DECISION DELEGATED TO HEAD OF PLANNING

Application No: H09-0879-24 **Applicant:** Mr R White
Proposal: Proposed New Garage/Workshop
Location: The Farm House Low Road Holbeach Hurn
Terminal Date: 6th January 2025

DRAW NO: OCT/RW/01/24
* A PLANNING REVISION ROOF LOWERED
REV 2/1

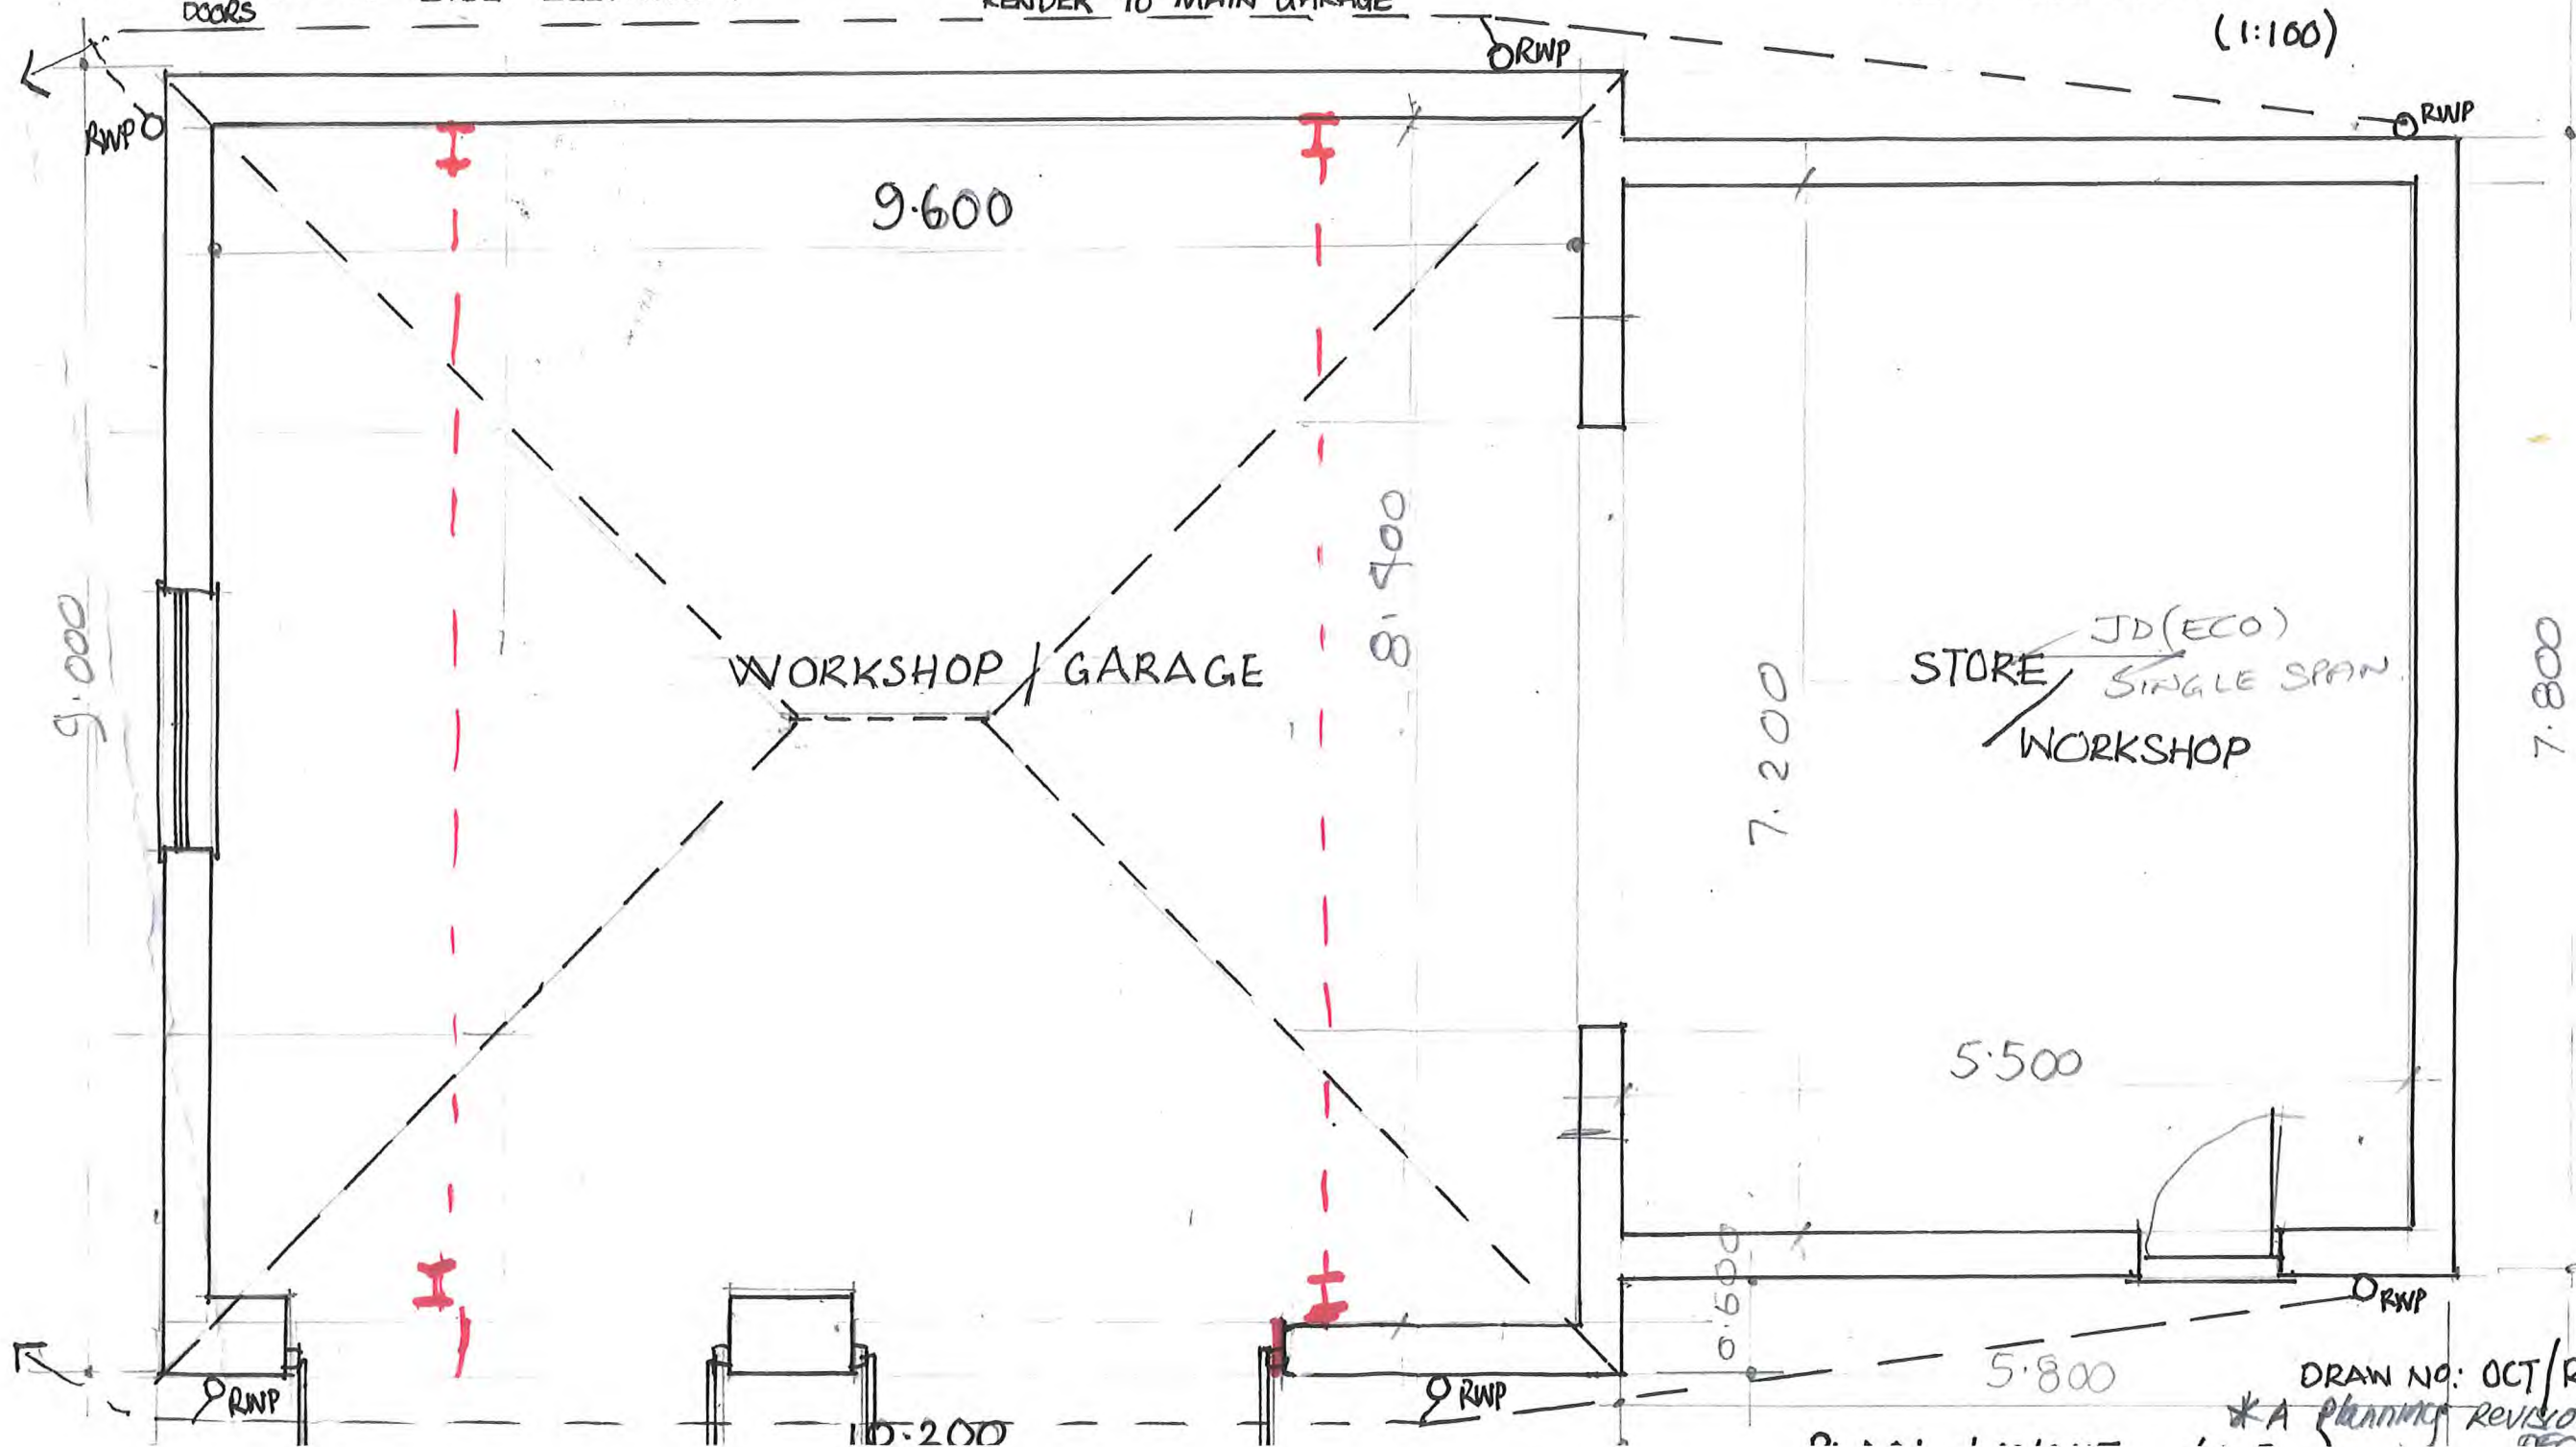
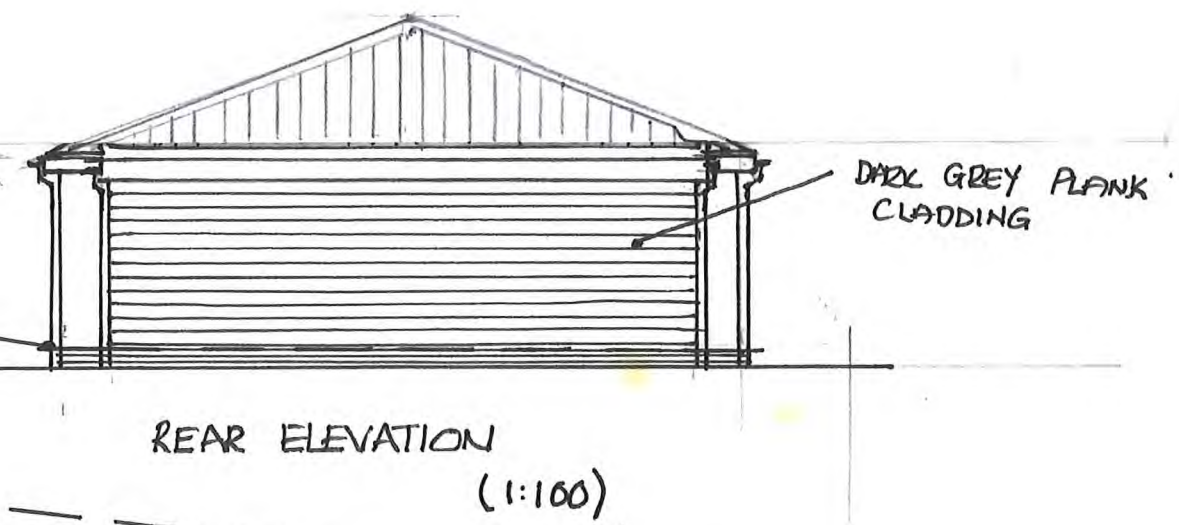
Request additional information: "The proposal also includes a revised access location . The access is to be constructed to Lincolnshire County Council Specification and a note should be added to the proposed block plan. Will the proposed garage/workshop result in any increased vehicle movements to/from the site?"

"The application is for a proposed New Garage/Workshop. There will be a revised access location, and the access construction should be to Lincolnshire County Council Specification. The existing access will need to be formally stopped up. The garage/workshop is for private use so there will not be any increase in vehicle movements to and from the site as a result of this proposal. As Lead Local Flood Authority, Lincolnshire County Council is required to provide a statutory planning consultation response with regard to drainage and surface water flood risk on all Major applications. This application is classified as a Minor Application and it is therefore the duty of the Local Planning Authority to consider the surface water flood risk and drainage proposals for this planning application

Planning Conditions: In the event that permission is to be given, the following planning conditions should be attached: Highway Condition 12 Within seven days of the new access being brought into use, the existing access onto Low Road shall be permanently closed in accordance with details to be agreed in writing with the Local Planning Authority. Reason: To reduce to a minimum, the number of individual access points to the site, in the interests of road safety"

DEAW NO: OCT-RW-03-2.4
*A Planning revision reduced Roof Height +
Dec.24.
SCALE: 1:100

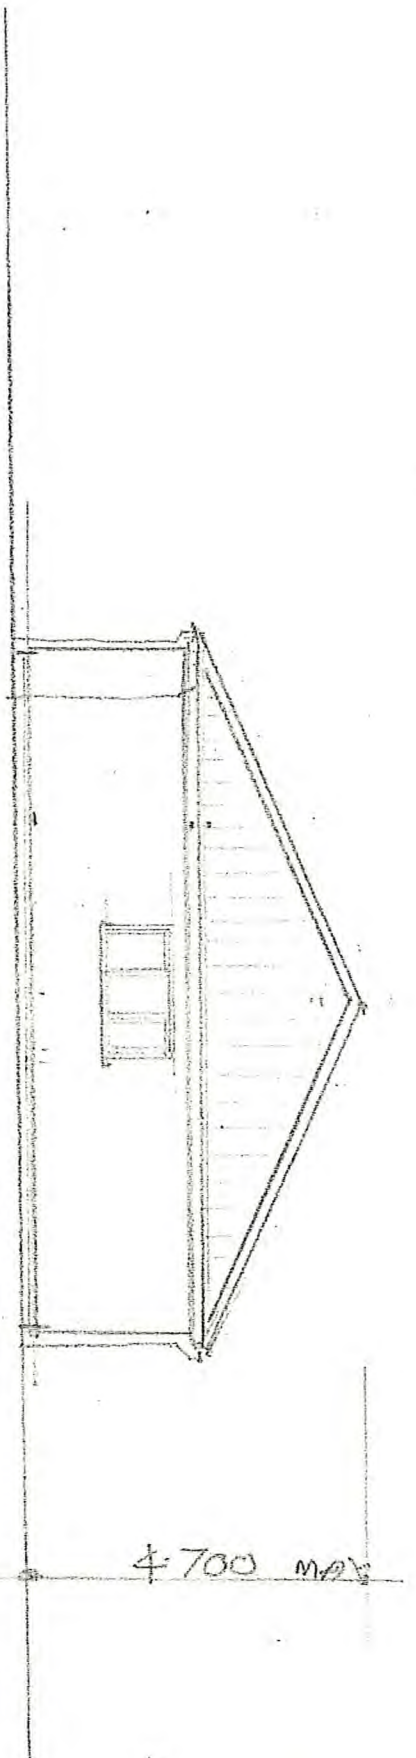
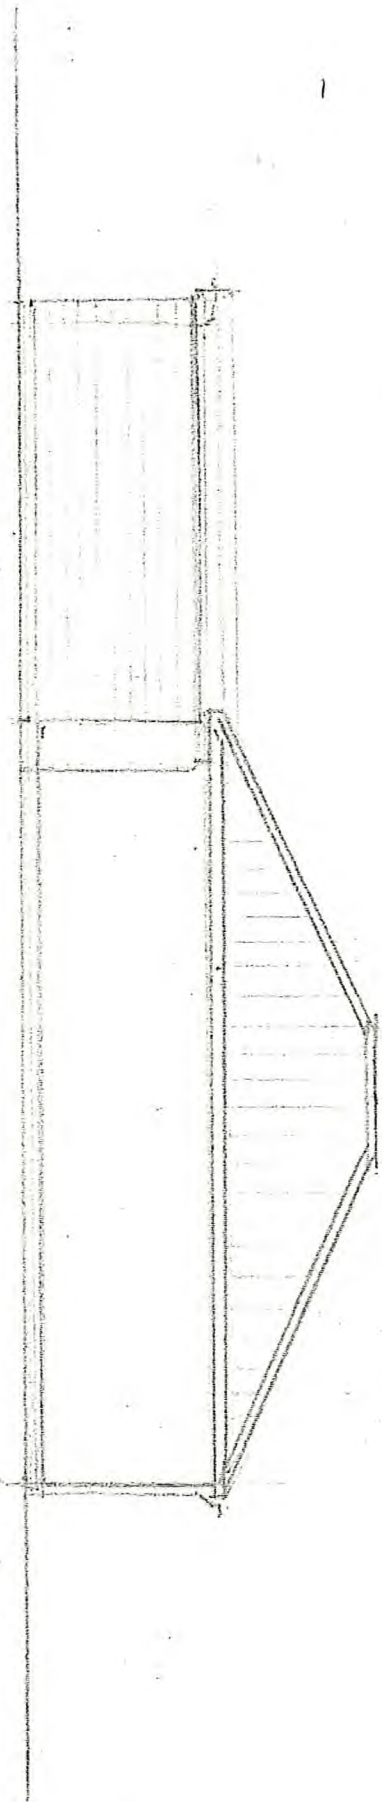
As outlined above, the garage is of significant scale. The footprint of the building, at 136sqm, is greater than that of the host dwelling. The maximum ridge height of the building, at 4.7 metres, is also significant, being greater than that of the existing single storey component over the dwelling. That being said, it is considered that the overall scale of the development is subservient to the host. This primarily is achieved via the lowered height to the eaves and the positioning of the building. It should also be noted that due to the scale of the curtilage, feasibly a building with a larger footprint (albeit with an alternative position) could be constructed under permitted development.

Irrespective of the above; however, is the consideration upon the wider visual impacts of the development. The building would be set back 7.3 metres from the highway. This 7.3 metre separation distance adequately reduces the visual impacts of the significant height. This separation distance ensures that a significant portion of the extension would be obscured by the existing boundary treatments along this boundary. While it is adjacent to the norther-eastern boundary, as this borders an agricultural plot, the effects of this are limited. Accordingly, the tangible impacts upon the character of the area are low.

"The adjustment to the roof ridge height does not affect the Board's previous comments of 28 October 2024 which still stand."
